## OFFICIAL NOTICE OF DECISION

**Project# 1007948**

09DRB-70275 MAJOR – SITE DEVELOPMENT PLAN FOR BUILDING PERMIT

SCOTT ANDERSON agent(s) for HB CONSTRUCTION request(s) the referenced/ above action(s) for all or a portion of Lot(s) 30, Block 4, Tract A, Unt B, **NORTH ALBUQUERQUE ACRES** zoned IP, located on the north side of BEVERLY HILLSAVE NE between SAN MATEO BLVD NE and the PAN AMERICAN FREEWAY containing approximately 0.8864 acre(s). (B-18)[*Deferred from 9/9/09, 9/16/09*]

**PLAT OF**  
**LOT 30-A, BLOCK 4, TRACT A, UNIT B**  
**NORTH ALBUQUERQUE ACRES**  
 PROJ. SEC. 12, T.11N., R.3E., N.M.P.M.  
 ELENA GALLEGOS LAND GRANT  
 ALBUQUERQUE, NEW MEXICO  
 OCTOBER 2009

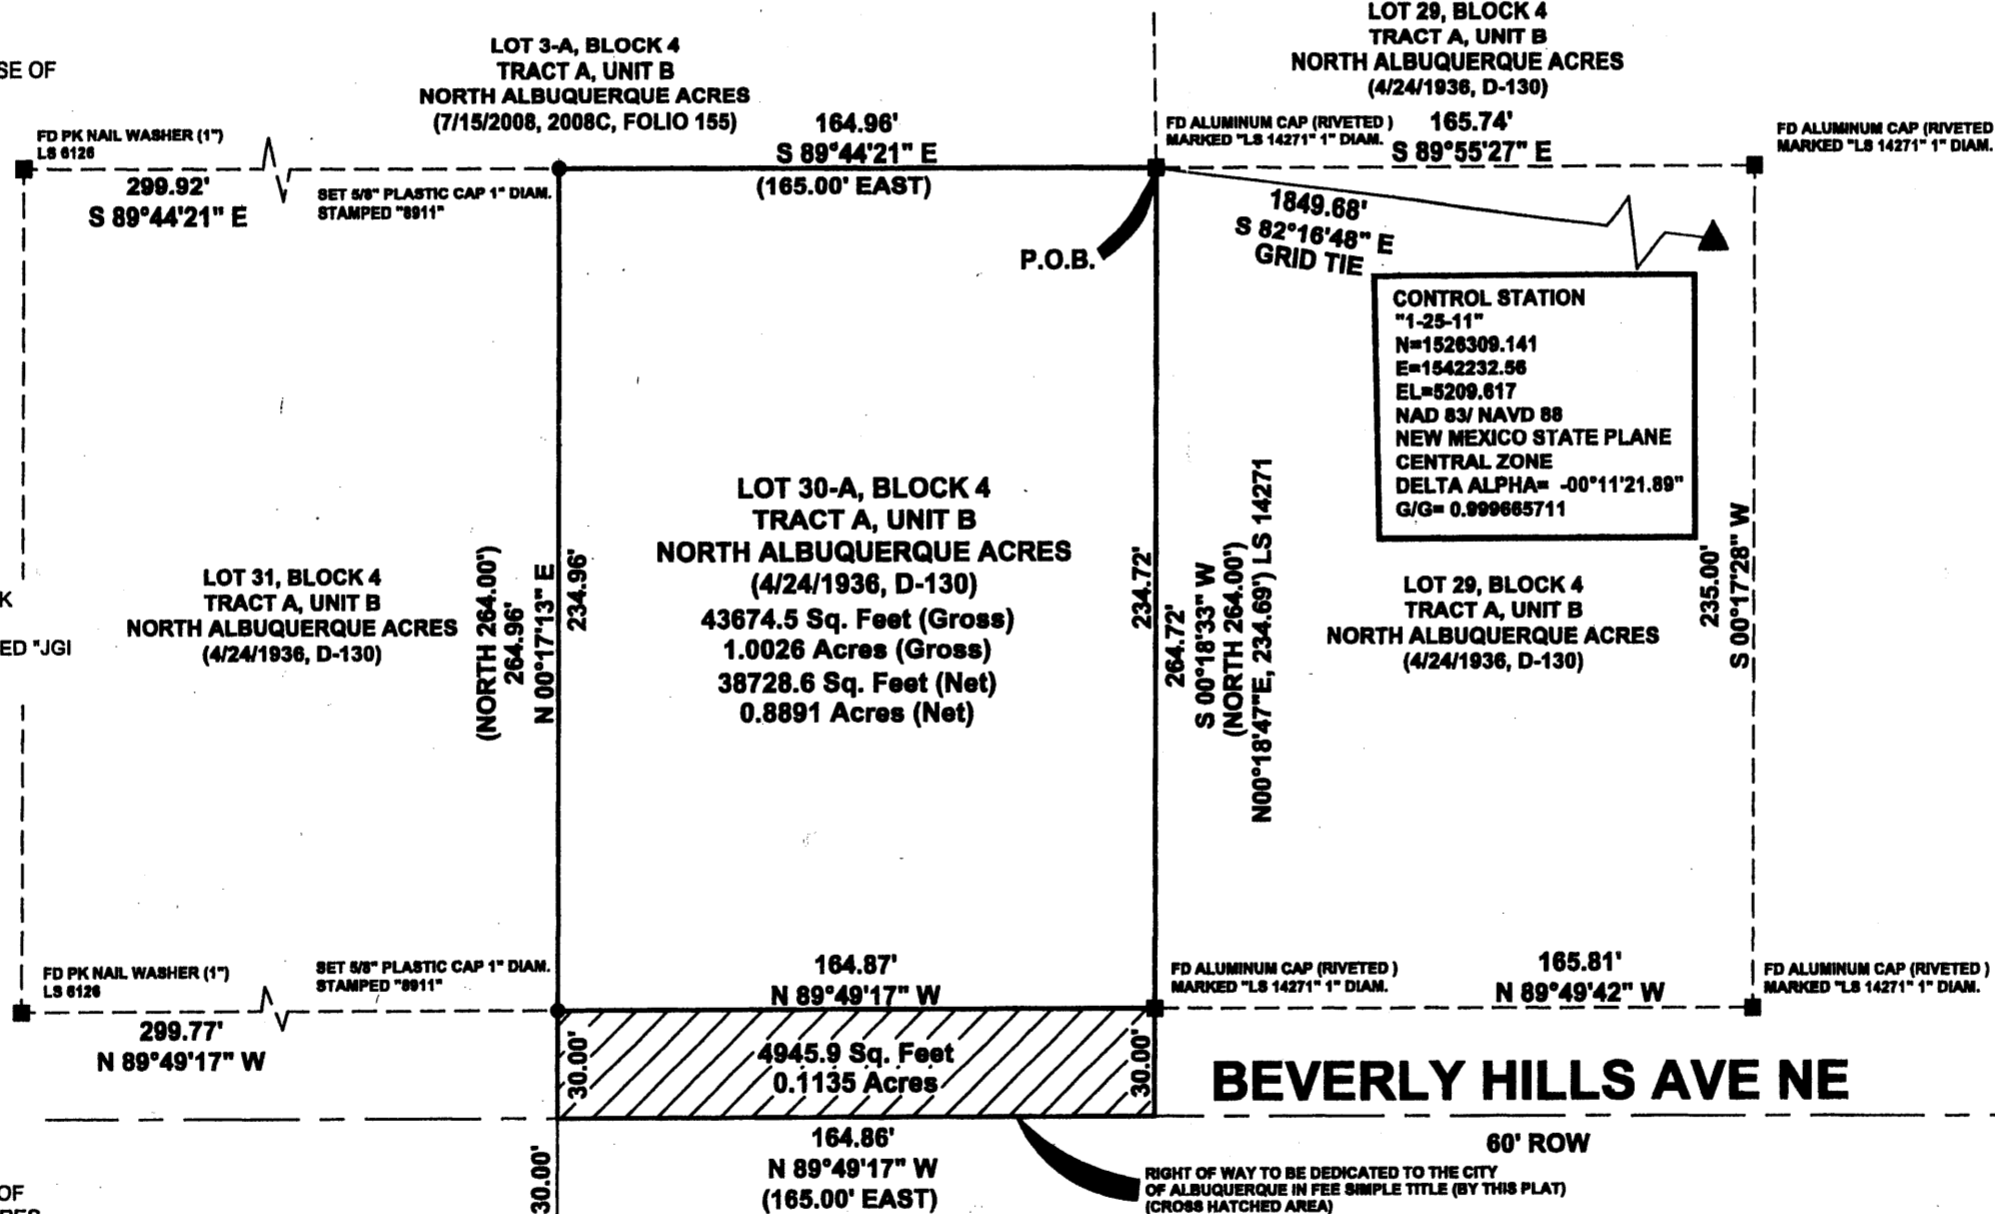
Please remove zoning note (10.) from plat. A Solar Note consistent with § 14-14-4-7 is required, specific to this type of request, i.e. use the words "THIS PLAT" (rather than the words "REQUESTED FINAL ACTION") at the beginning of the note, and do not use the words "OR SITE DEVELOPMENT PLAN FOR SUBDIVISION" at the end of the note.

**SITE PLAN**

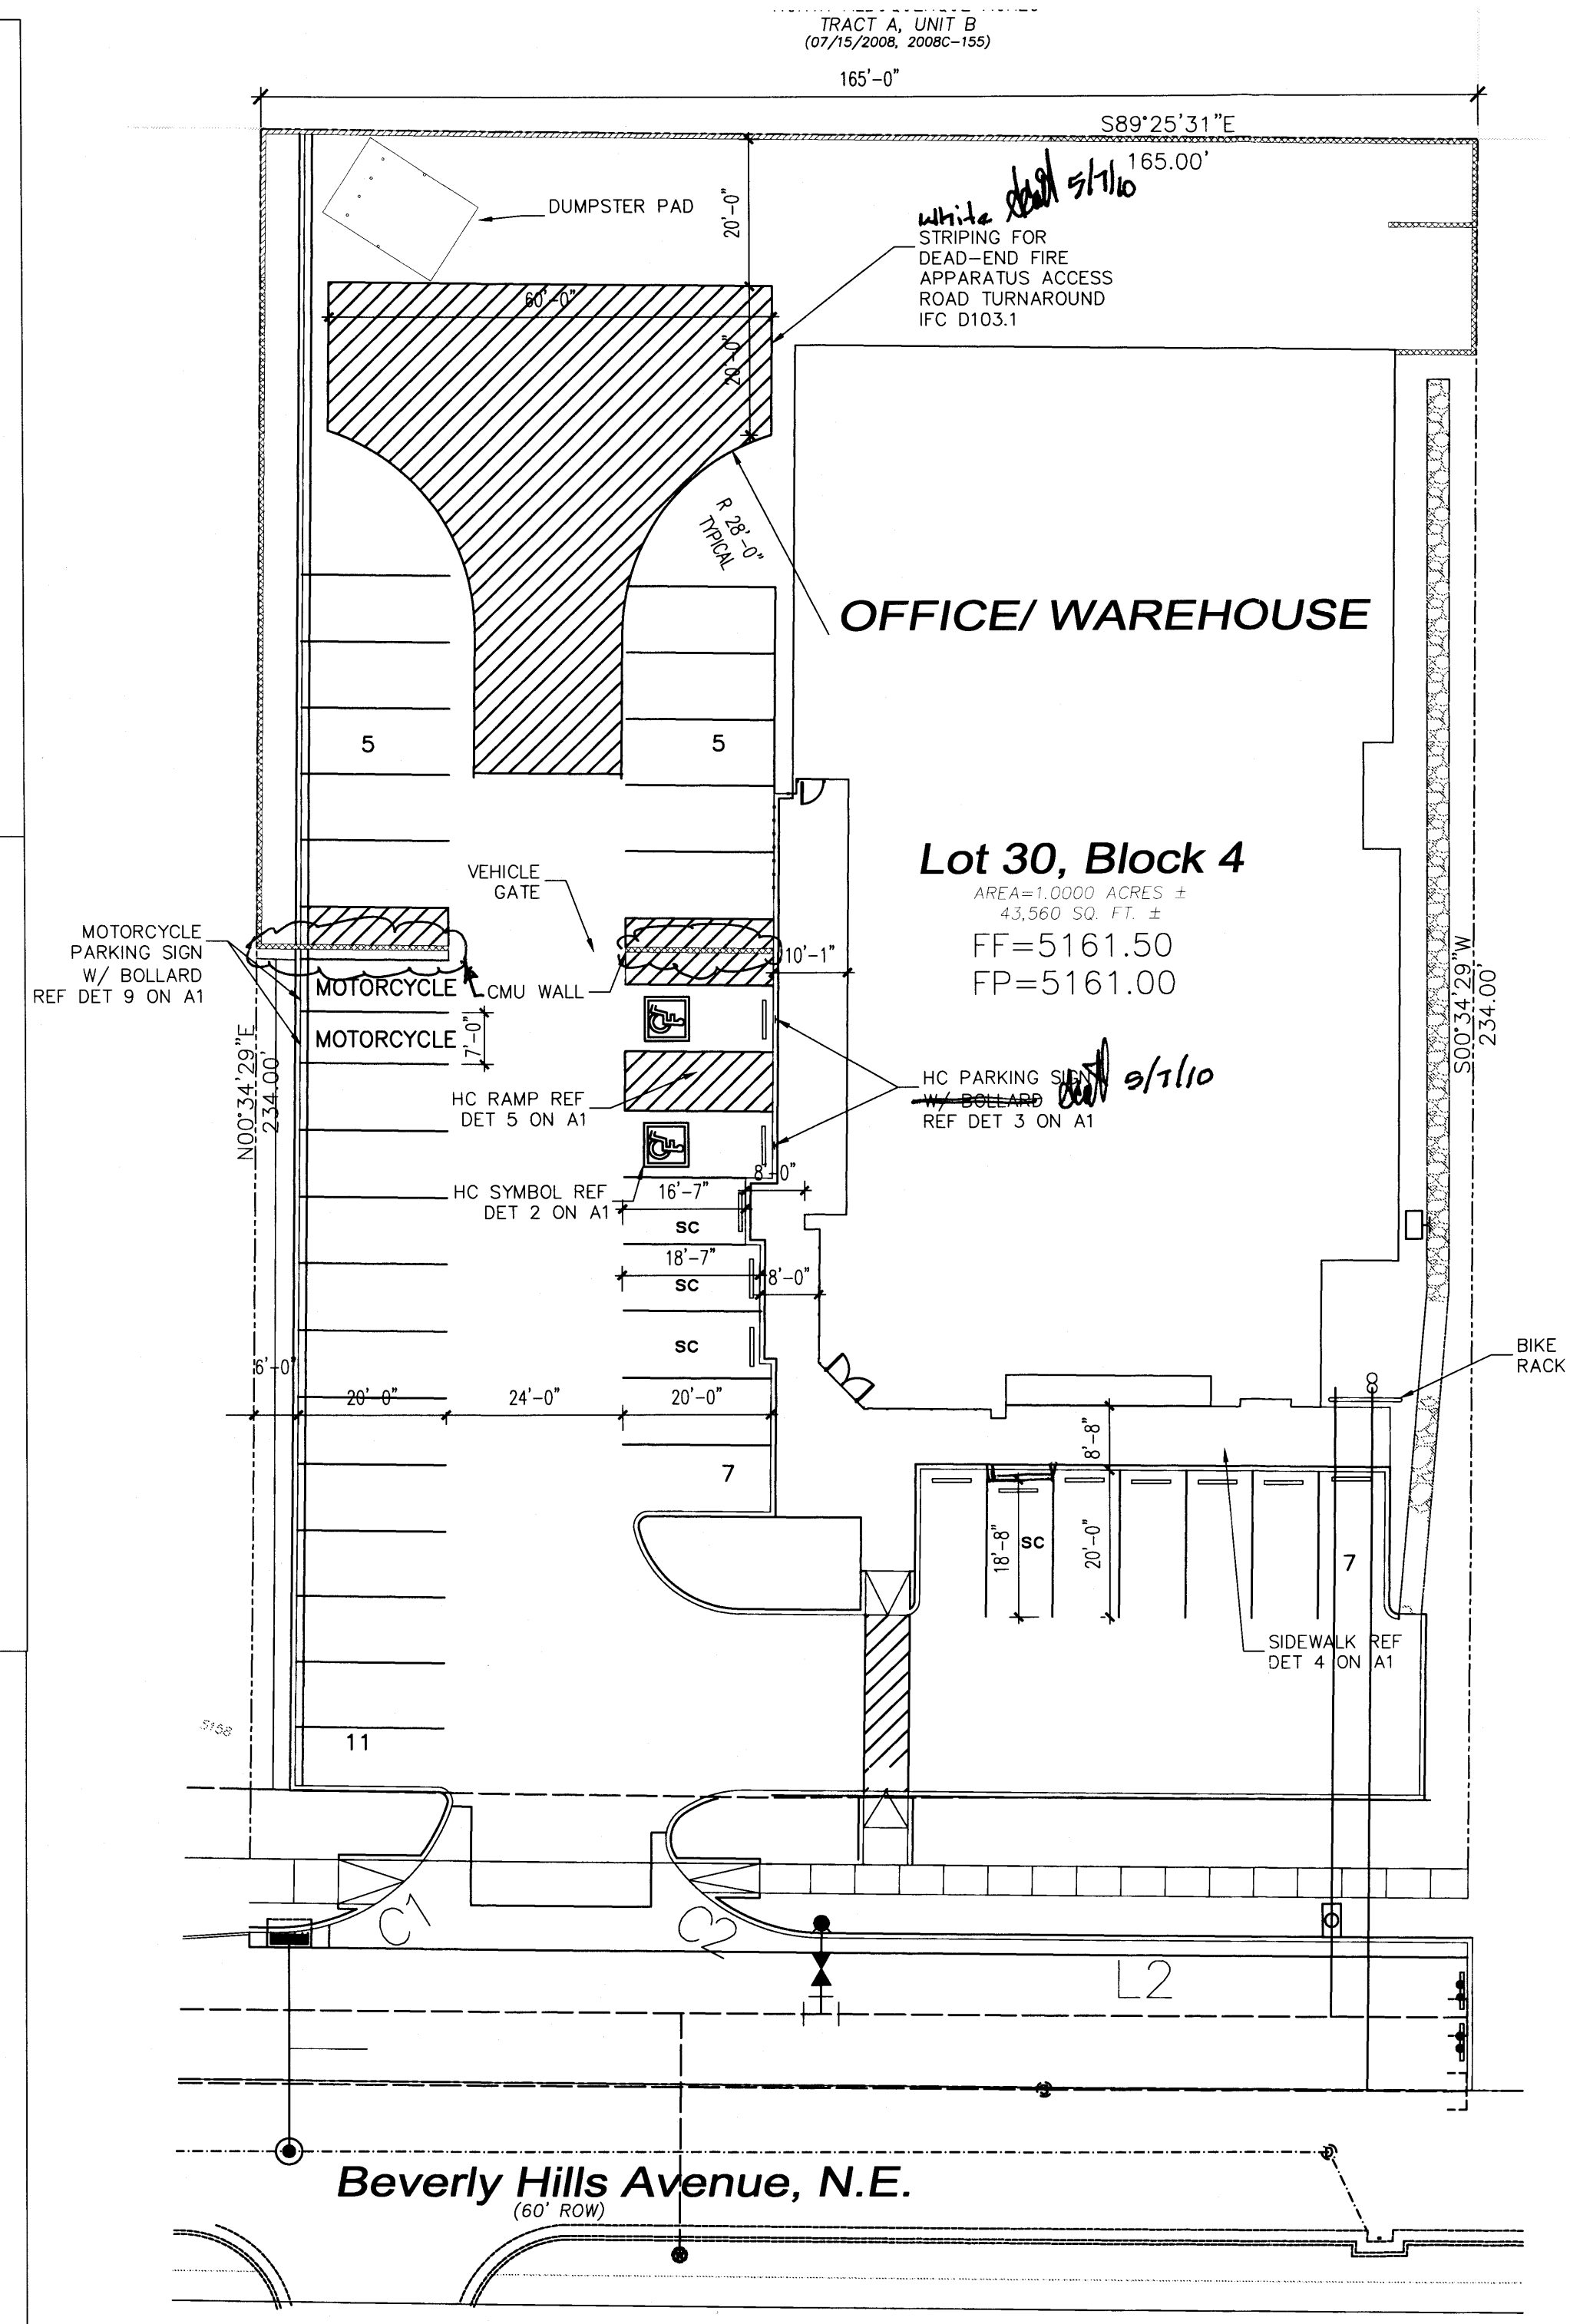
Regarding the site development plan delegated for final sign-off on September 23, 2009, parking calculations still need to be corrected – while PARKING REQUIRED is 34 spaces, that is also the number of PARKING PROVIDED spaces, not 35 (9 spaces are provided on west side of building, not 10). Only 2 BIKE SPACES REQUIRED, not 4 [§ 14-16-3-1 (B)(3)], but location of Bike Rack needs to be indicated on the site plan. Finally, separate Motorcycle Parking (2 spaces visible from the entrance of the building, with signage) is also required [§ 14-16-3-1 (C)].

Build notes, referring to the specific City Standard, must be provided for all proposed items within the City right of way (curb and gutter, ramps, sidewalk, curb cuts, etc.).  
Call out the width of the proposed drivepad.  
The handicapped spaces must include an 8-foot wide van access aisle  
Clearly demonstrate the 6-foot wide, ADA accessible, pedestrian pathway from the roadway to the building.  
All proposed ramps located within the public right of way must have truncated domes.  
Provide details for all wheelchair ramps; define the maximum slope.  
Call out the width of all sidewalk.  
Clarify the status of paving along Beverly Hills Avenue. A paved connection from City Right of Way to the proposed site must exist or be built with this project.  
**How was the taper length determined? Please provided City standards length. Will be determine at DRC.**

Build notes, referring to the specific City Standard, must be provided for all proposed items within the City right of way (curb and gutter, ramps, sidewalk, curb cuts, etc.).

Call out the width of the proposed drivepad.

The handicapped spaces must include an 8-foot wide van access aisle

Clearly demonstrate the 6-foot wide, ADA accessible, pedestrian pathway from the roadway to the building.

Call out the width of all sidewalk.

Clarify the status of paving along Beverly Hills Avenue. A paved connection from City Right of Way to the proposed site must exist or be built with this project.

**UNI-DIRECTIONAL WHEELCHAIR RAMP DETAIL (TYP.)**  
NTS

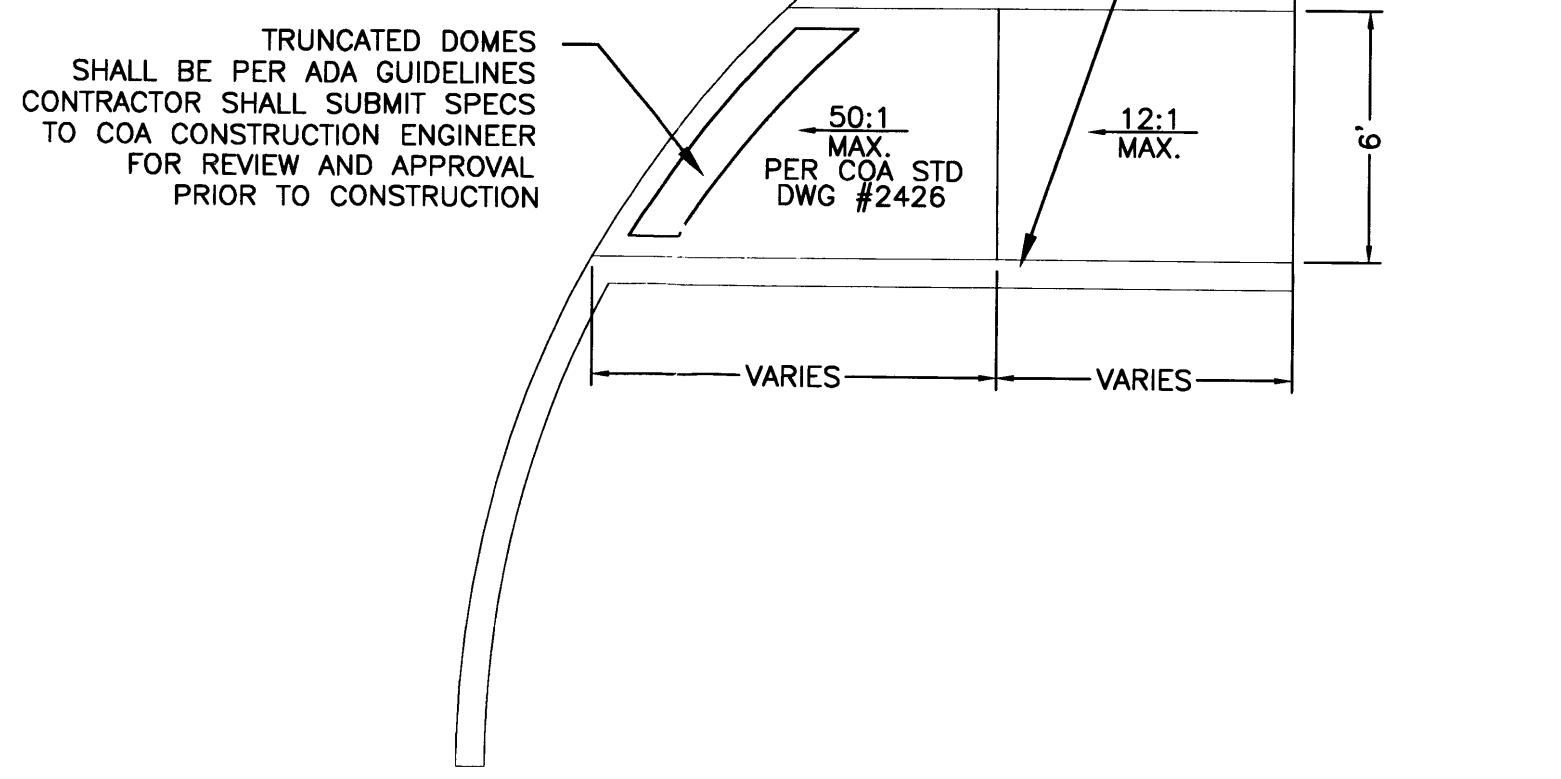
All proposed ramps located within the public right of way must have truncated domes.

Provide details for all wheelchair ramps; define the maximum slope.
